Consultation Response from KC, Highways Development Management (HDM)

2023/91116 Land off, Primrose Lane, Hightown, Liversedge, WF15

Erection of 77 dwellings

Date Responded: 22/11/24

LONG SECTION: MS001 Alignment
SCALE: H:500, V:500
DATUM: 85.00

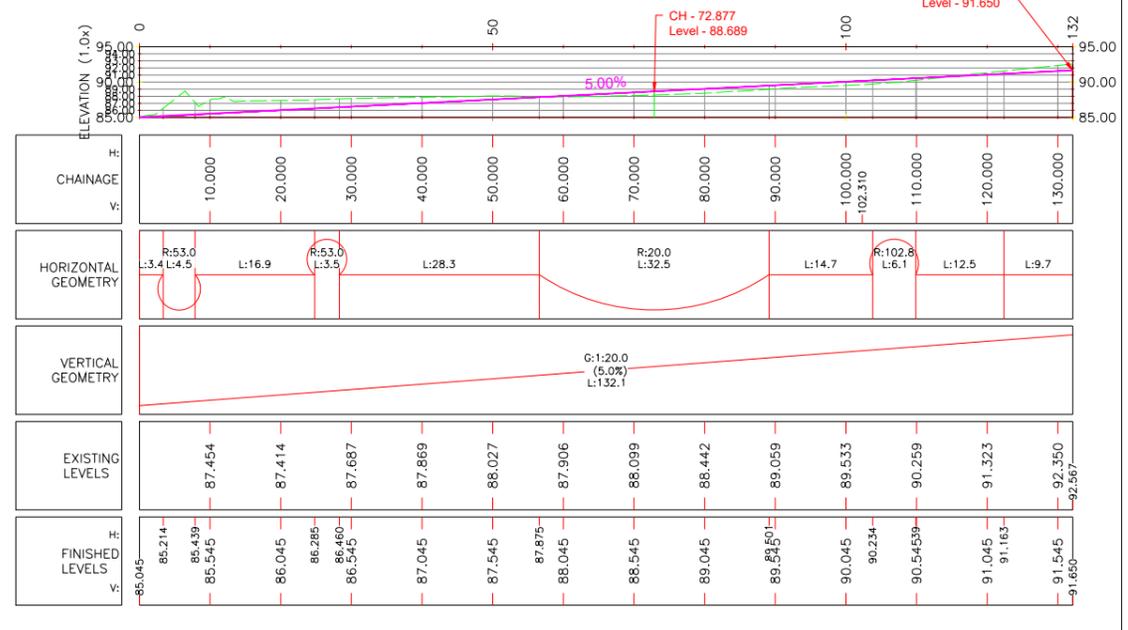
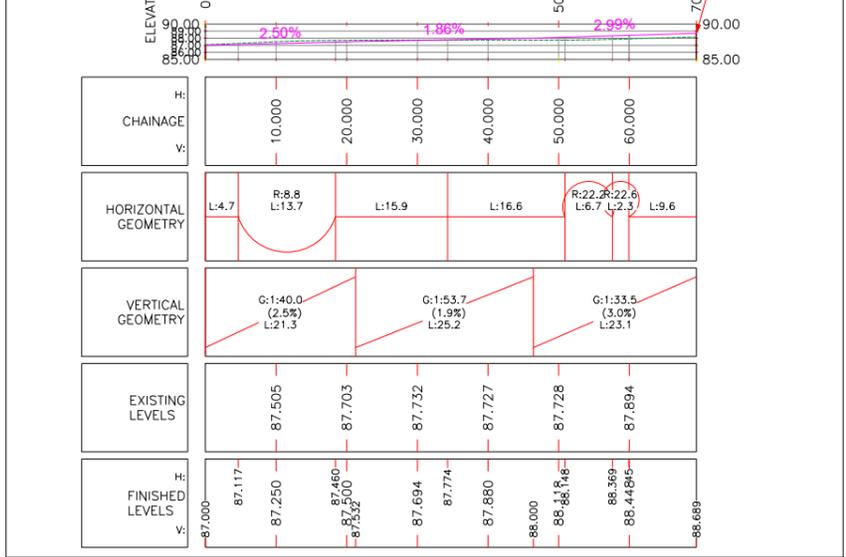
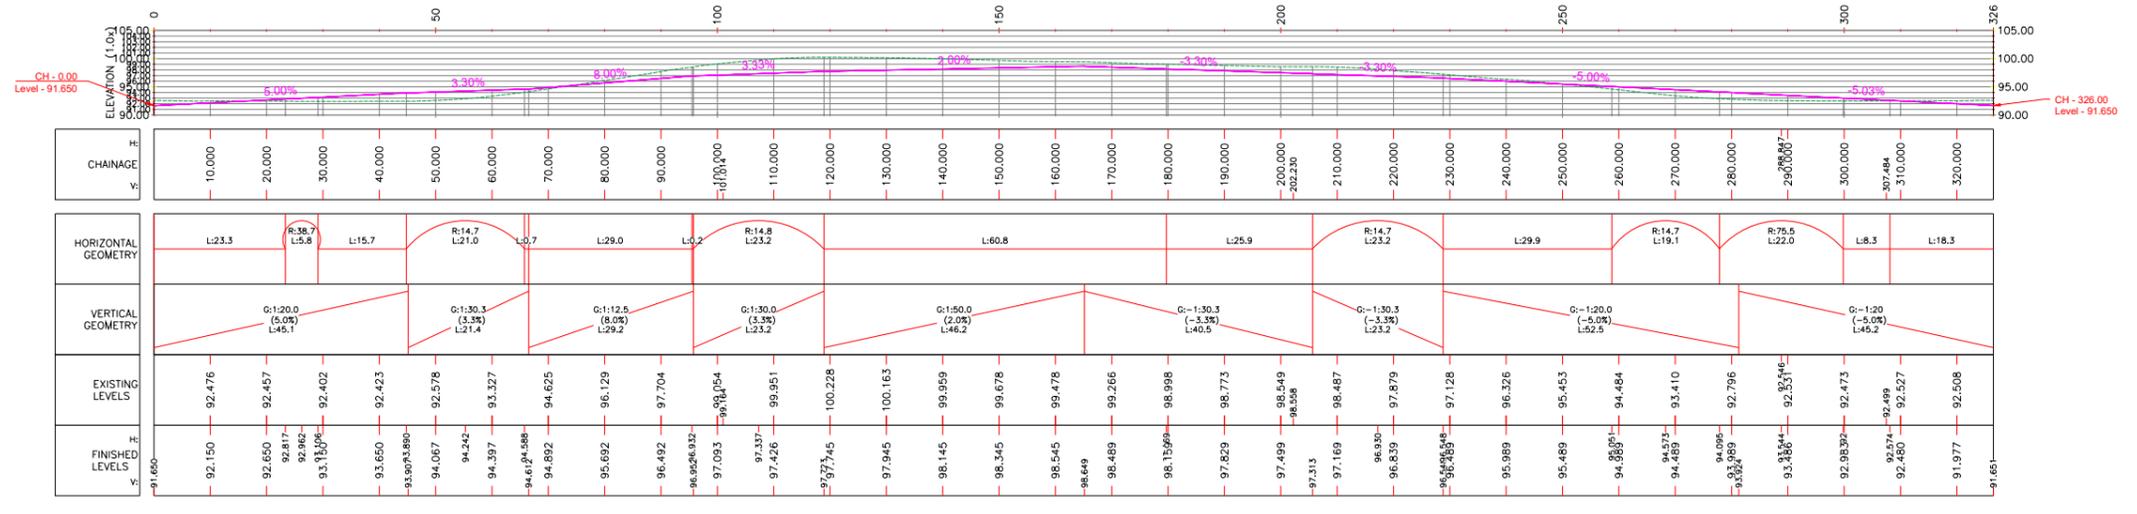
Notwithstanding the above, some of the highways details shown on the submitted plans are not acceptable, and will need to be reviewed further at the detailed design stage. This includes the vertical alignment of the proposed roads, which do not currently demonstrate adequate alignments (e.g. no vertical curves have been shown) and some of the paving details do not correspond to our S38 standard details. Therefore, further details of the highway arrangements (including roads and active travel links) should be secured by planning conditions.

Inset 1a - Online Delivery Vehicle

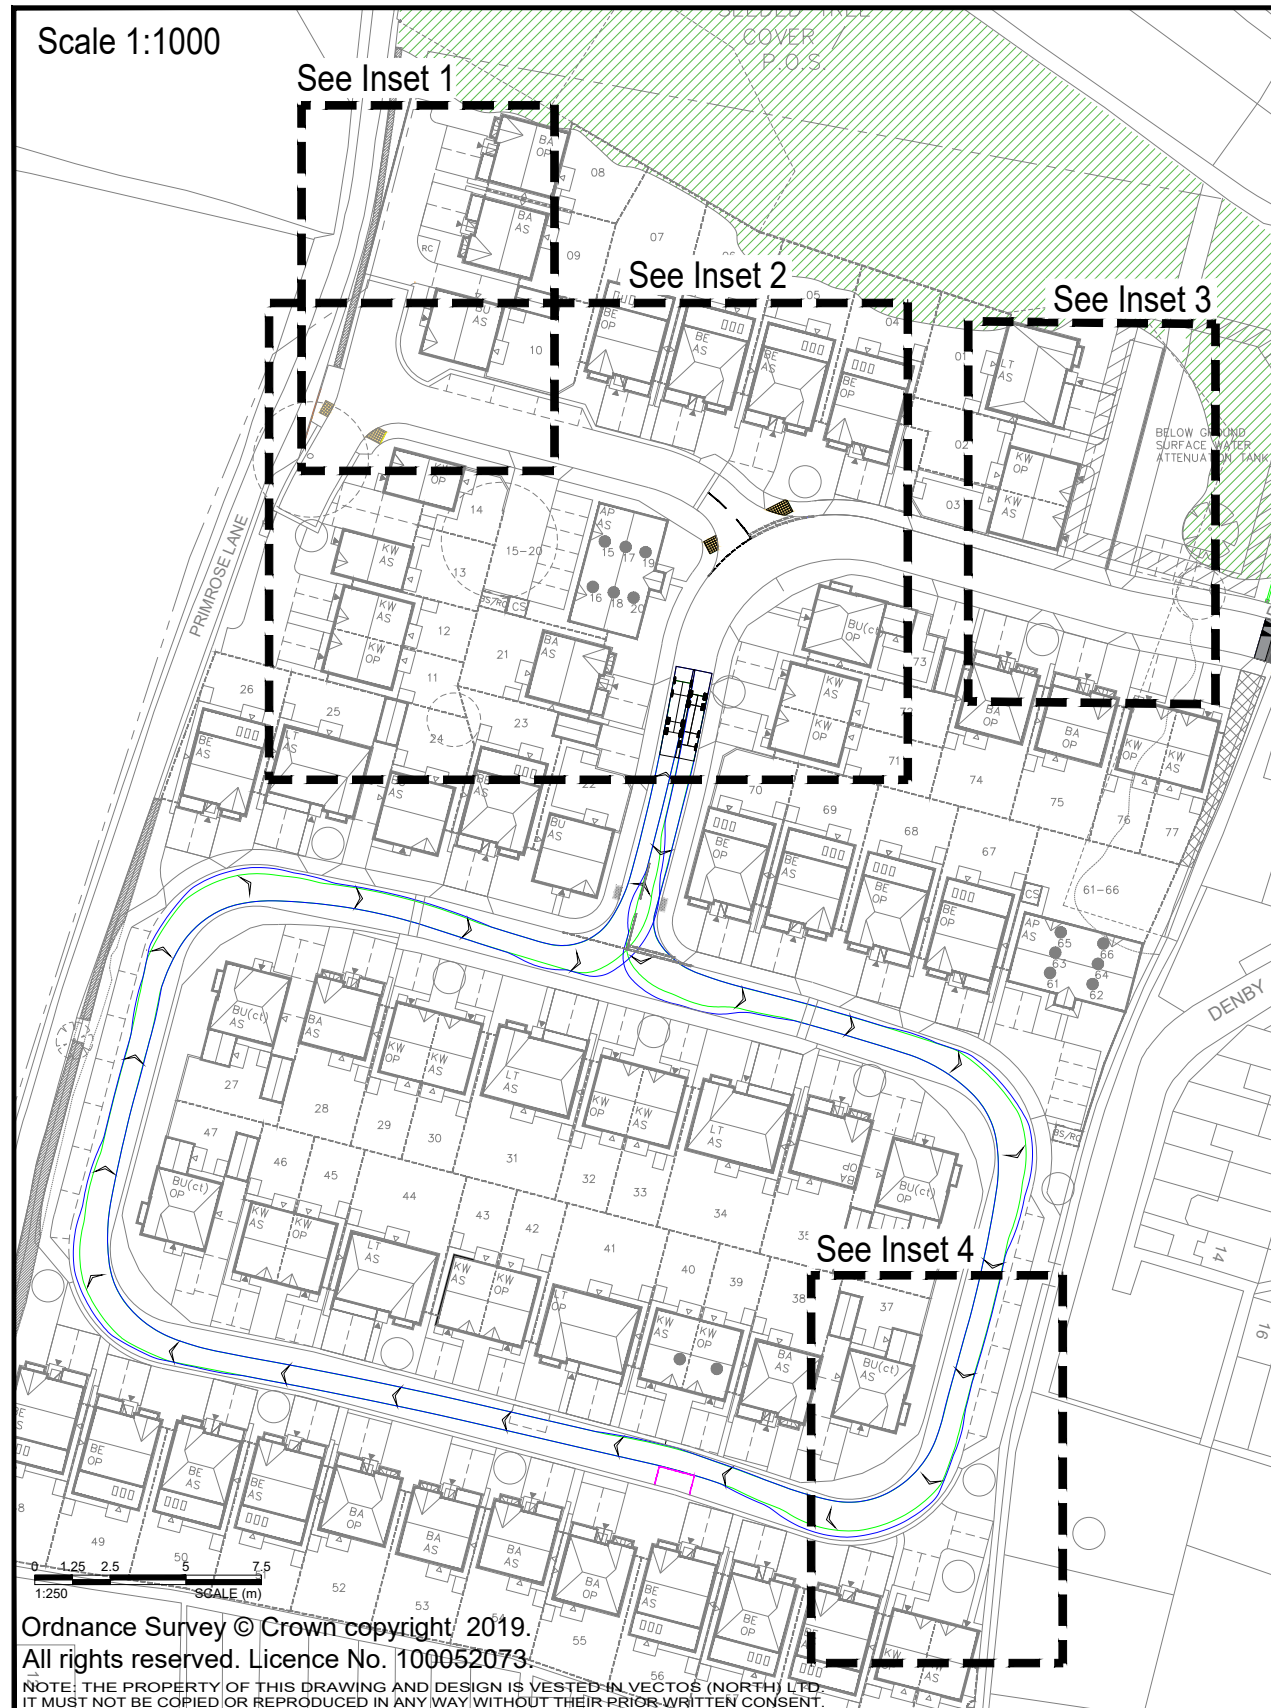
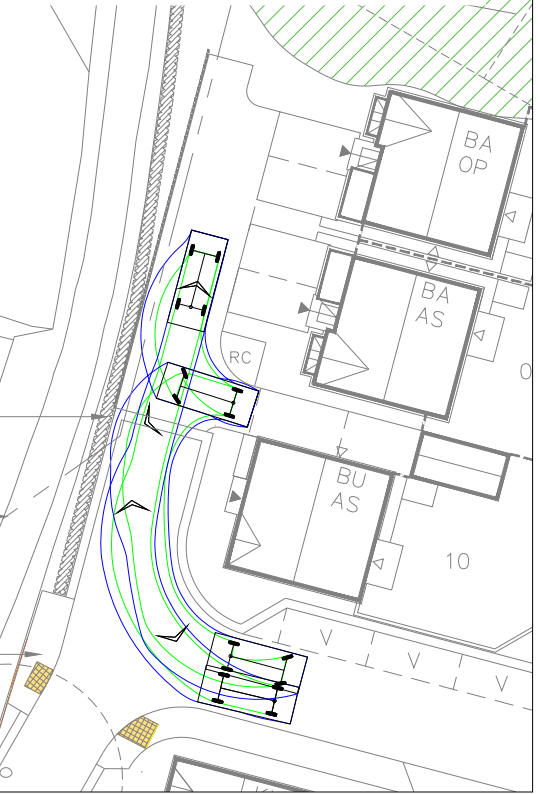
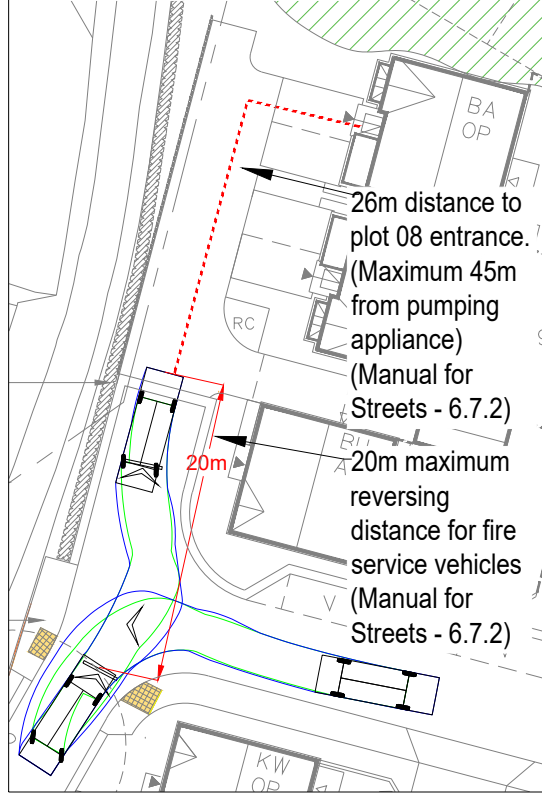
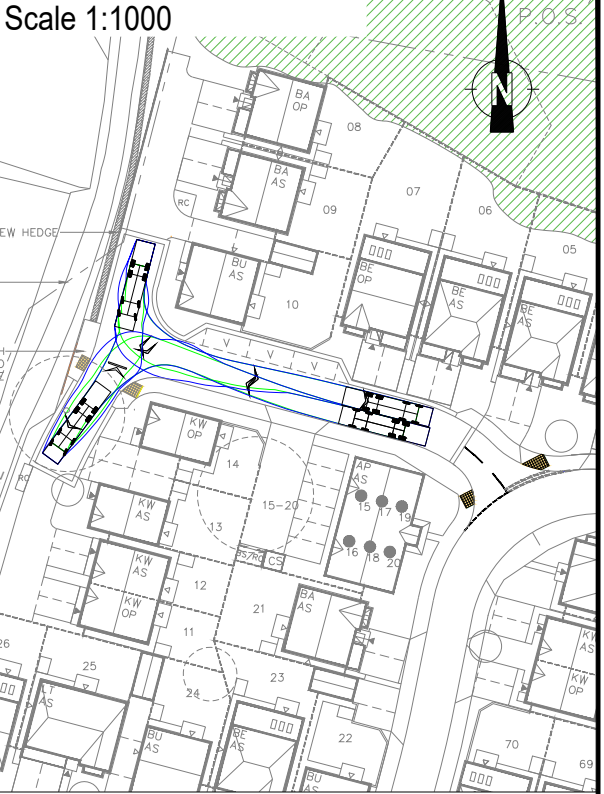
The design team has provided swept path analysis for the site layout, which confirms that the Councils design refuse vehicle (11.85m long) can circulate the loop road system within the site and can also turn at the proposed turning head in the northwest corner of the site.

PRIMROSE LANE
 PROPOSED SITE LAYOUT

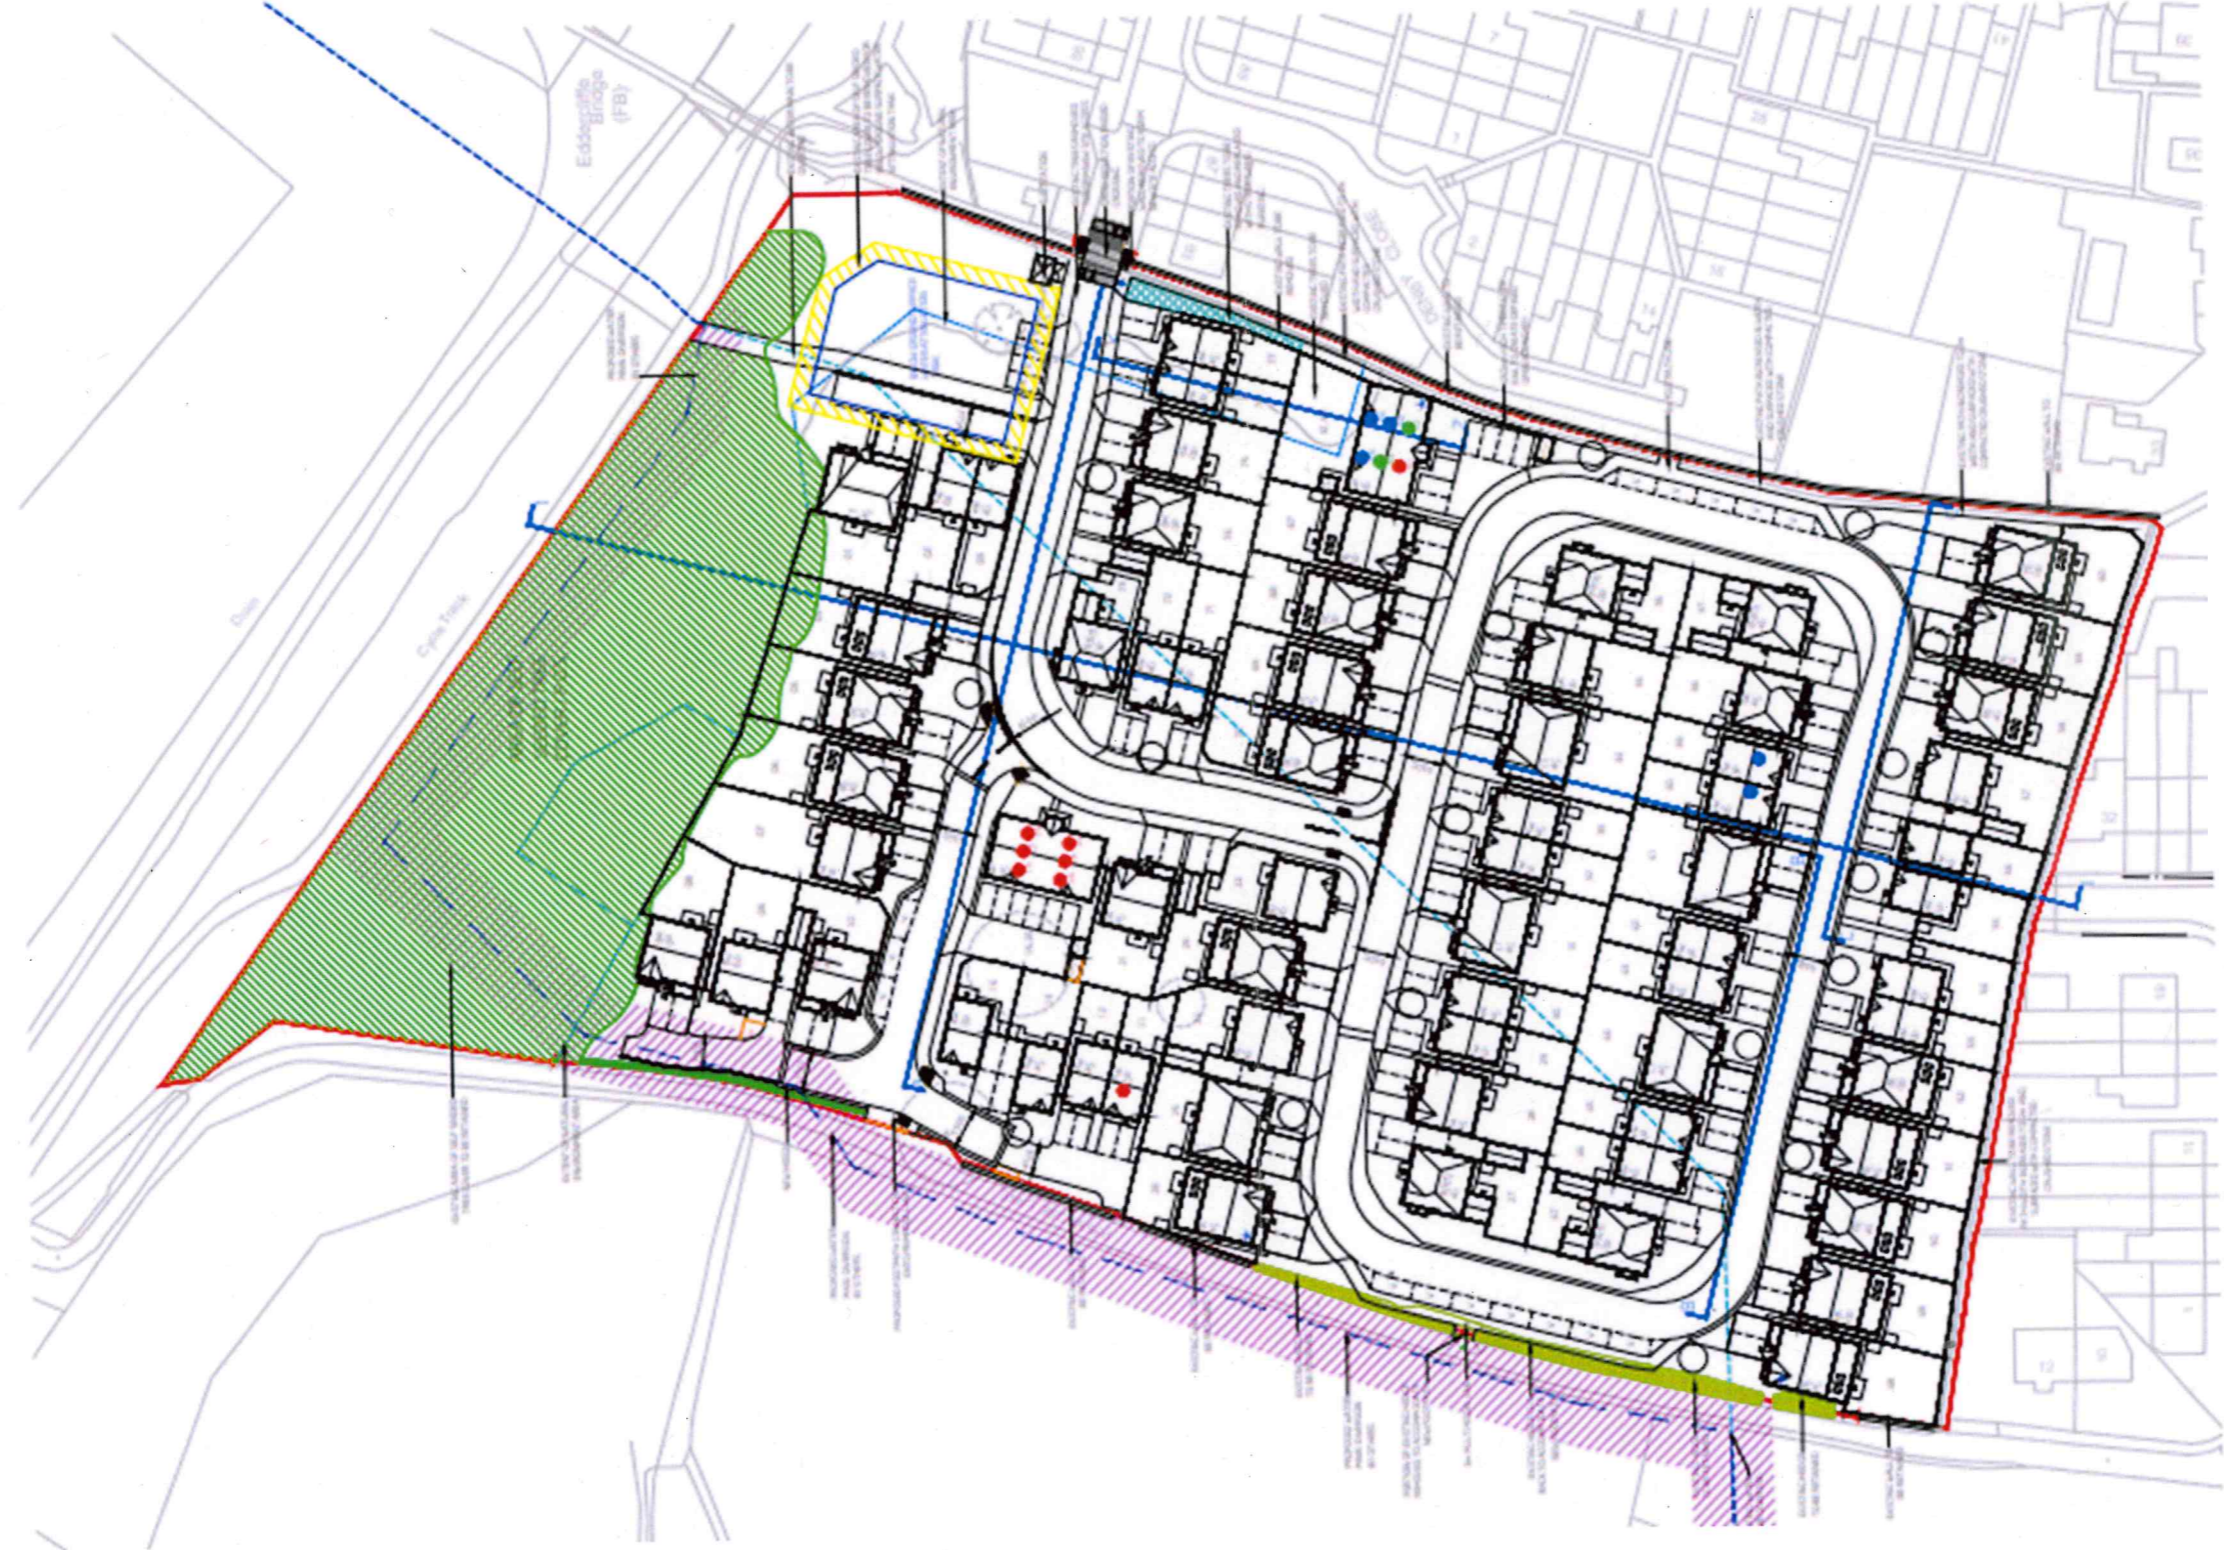
- A 3m wide active travel link has been proposed from the proposed estate road to the Spen Valley Greenway to the north. This link is proposed at 3m wide and with a maximum gradient of 1:12. This link is welcome and is acceptable in principle. However, the detail design of the link will need to be secured by condition, which will need to include the provision of adequate junction visibility at the connection with the greenway (this point has also been identified as an issue in the Stage 1 RSA).

- 2 no. active travel links are proposed along the western site boundary, which connect the site to Public Bridleway SPE/111/120 on Primrose Lane. Both links are proposed at 3m wide, with maximum gradient of 1:20. These links are welcome and are acceptable in principle. However, it is noted that the annotation on the Proposed Site Layout drawing 3416-1-0014 Rev QQ appears to be incorrect, with the northern link being shown as a footpath link and the southern link being shown as a multi-modal use, when in fact these should be the opposite way around (as the southern link may only be adequate for pedestrians, due to the adjacent parking layby preventing access for cyclists). Therefore, the detail design of these active travel links will need to be secured by condition, which will also need to include the provision of adequate junction visibility at the connection with the greenway (this point has again been identified as an issue in the Stage 1 RSA).

- A speed table is proposed on the initial section of site access road, where footpaths SPE/110/20 crosses the access, to ensure that traffic speeds are low at the crossing point, and to provide a level surface route for pedestrians.

Secure cycle storage is required for all dwellings. For the majority of dwellings, cycle storage will be in garages. However, for any dwellings without garages (e.g. the apartments) separate secure/covered cycle stores will be required. These have been shown indicatively on the plan. However, the final details of cycle storage for all dwellings should be secured by condition.
